Planning Application Reference No.: 3/2026/0452

Address of Development: 3a swan courtyard castle street clitheroe bb72dq

From: [REDACTED] >
Sent: 17 August 2026 16:46
To: Planning
Subject: Re appln 3/2026/0452

South West Elevation

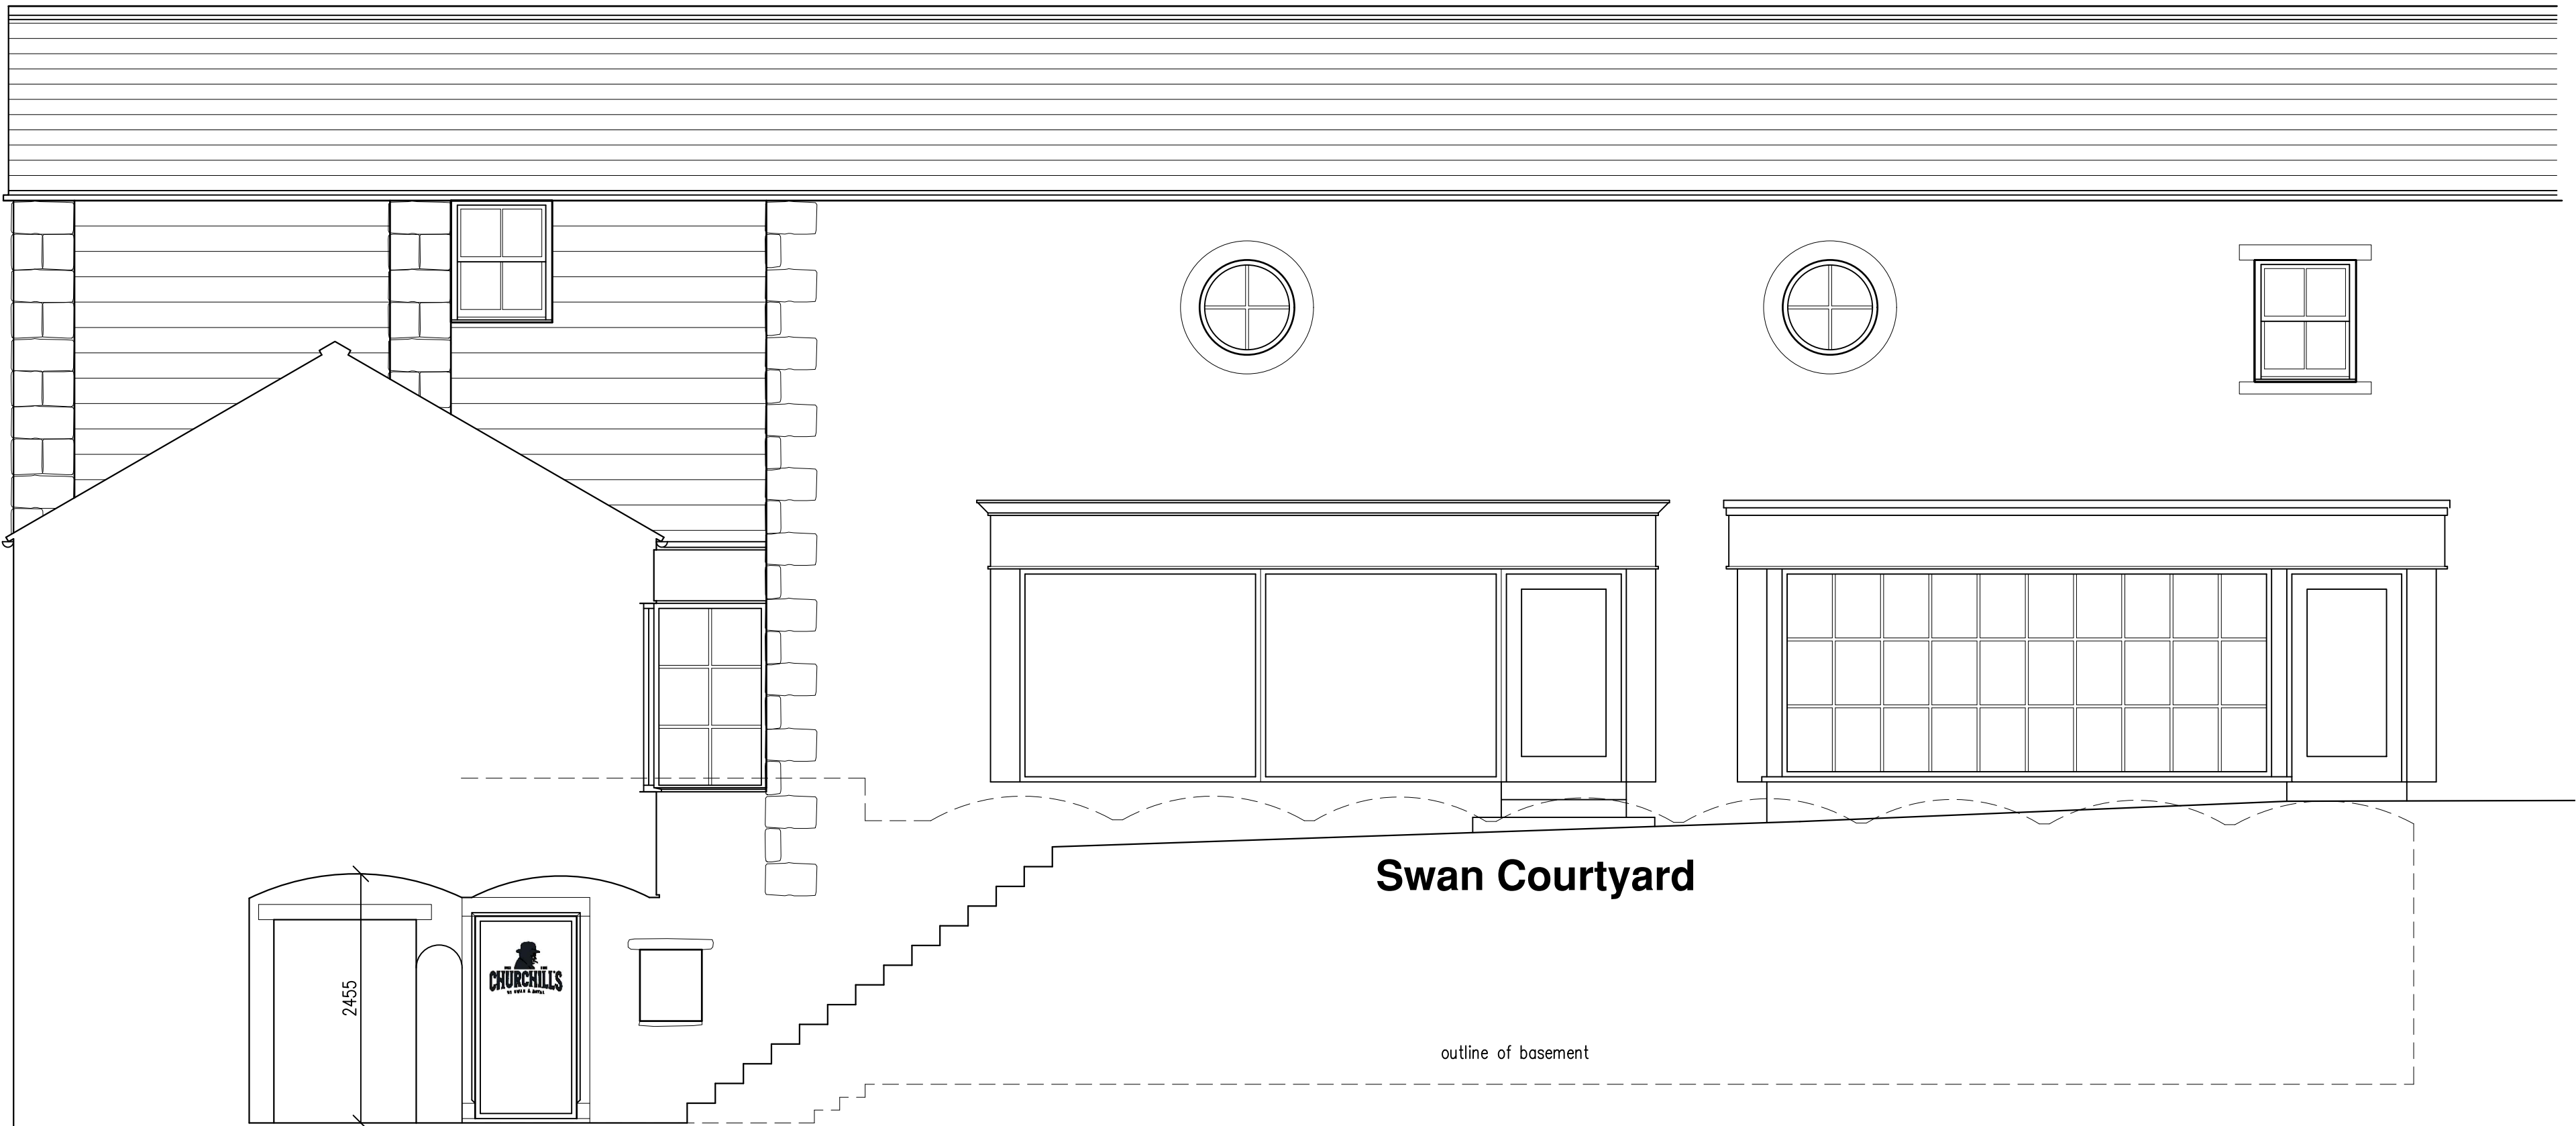
We note that individual extractor fans will be present for the new male and female loos - however plans should still detail the location and scale of these for planning consideration.

job: Proposed Restaurant & Bar 3A Swan Courtyard Clitheroe BB7 2DQ client: Mr L Nuttall		
drawing: Proposed		
scale: 1:50, 1:20 @ A1	date: 04/26	drawn: smc
job no: 30/2026	drawing no: 02	F

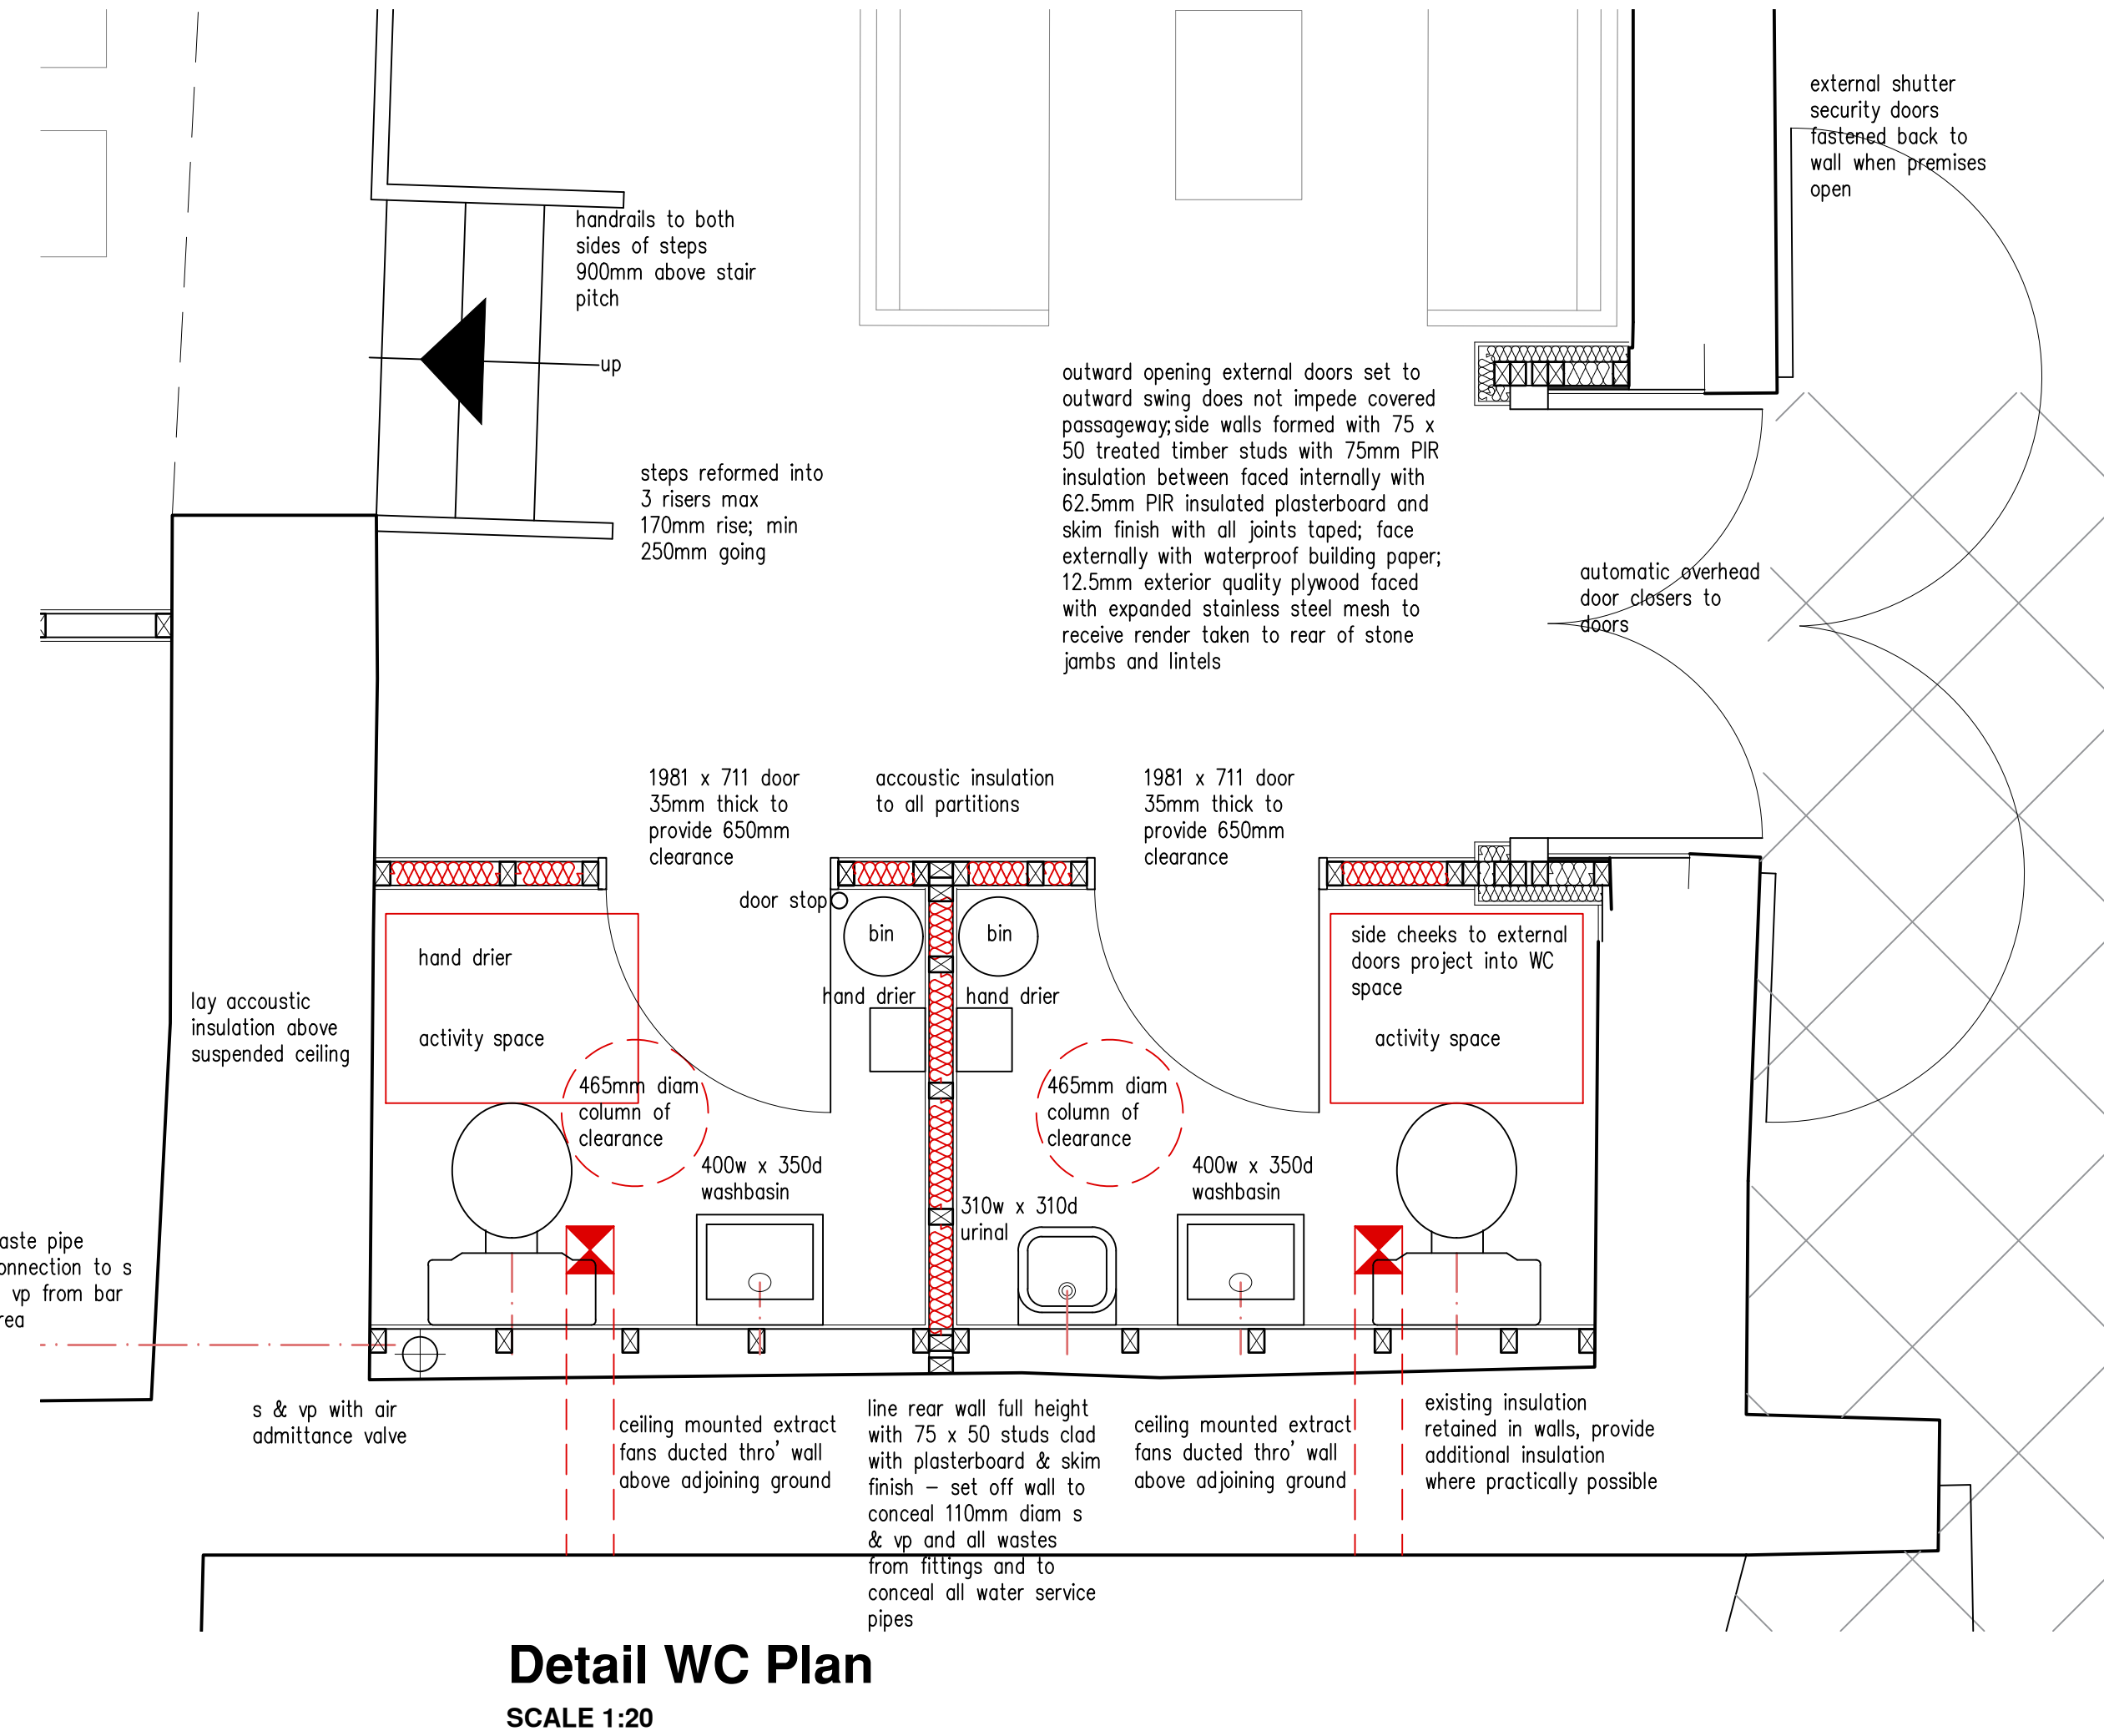
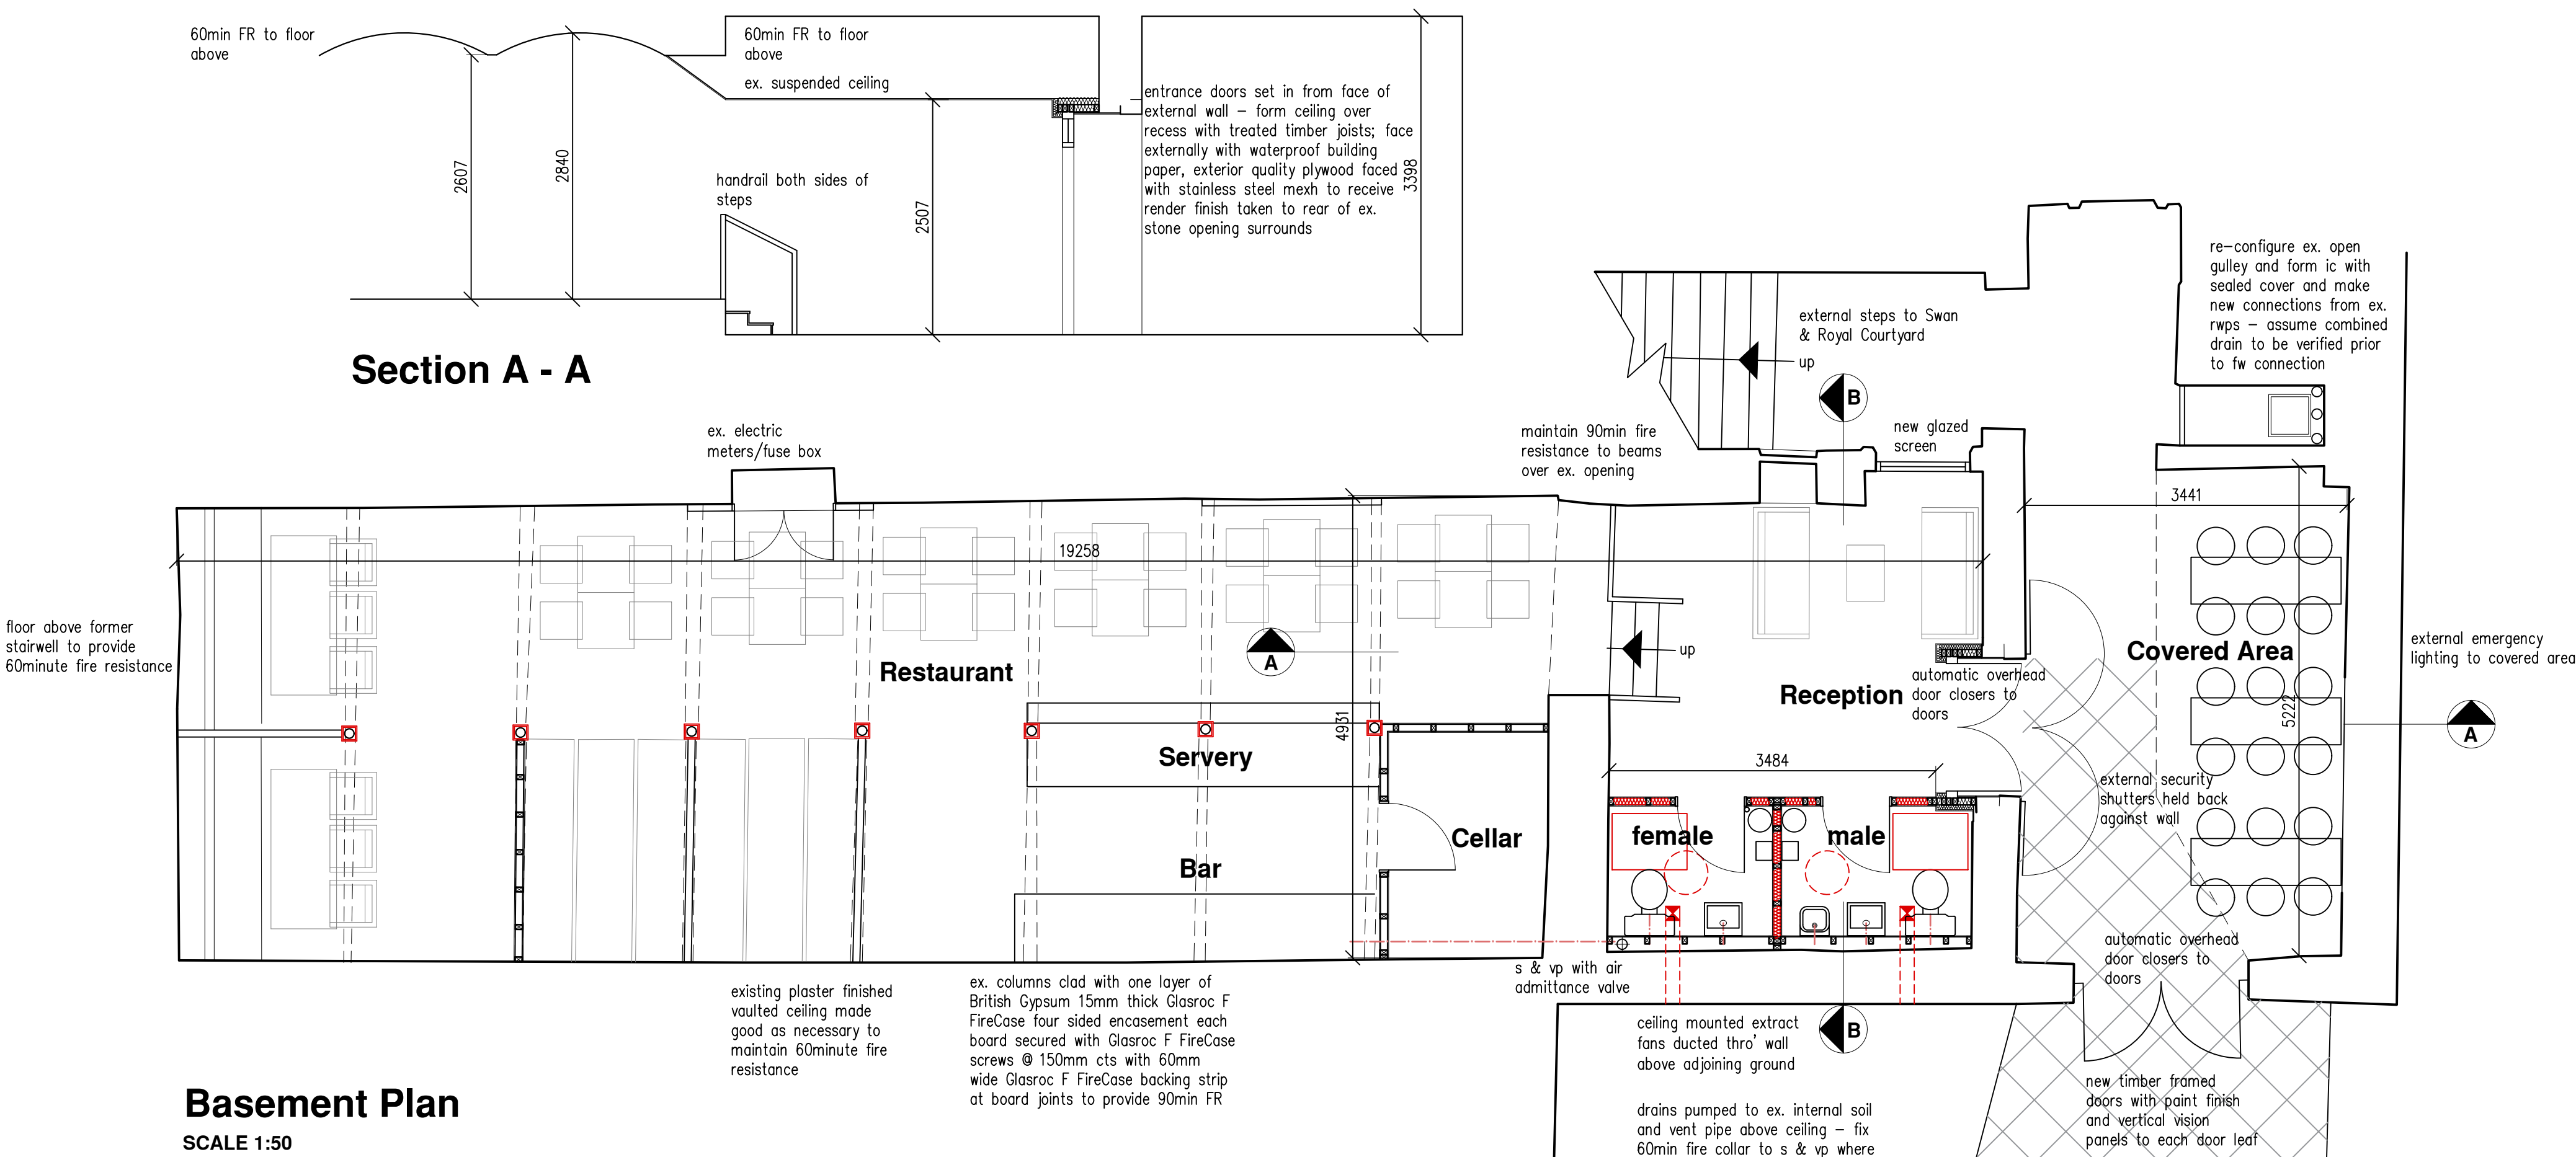
In respect of the archway access, it's good to know that it is 'not intended to restrict public access' however the statement also says 'proposed to remain open at all times during normal operating hours'. I assume that this means that the doors will always be open during operating hours - with free access etc - what about outside of operating hours - will the doors simply be closed but still openable by anyone, at any time - or what is the exact intention? This still needs some clarification as whilst we welcome the intention to maintain public access, it's important that nothing is put in place that provides the opportunity to restrict that now, or at any time in the future, regardless of the time of operation.
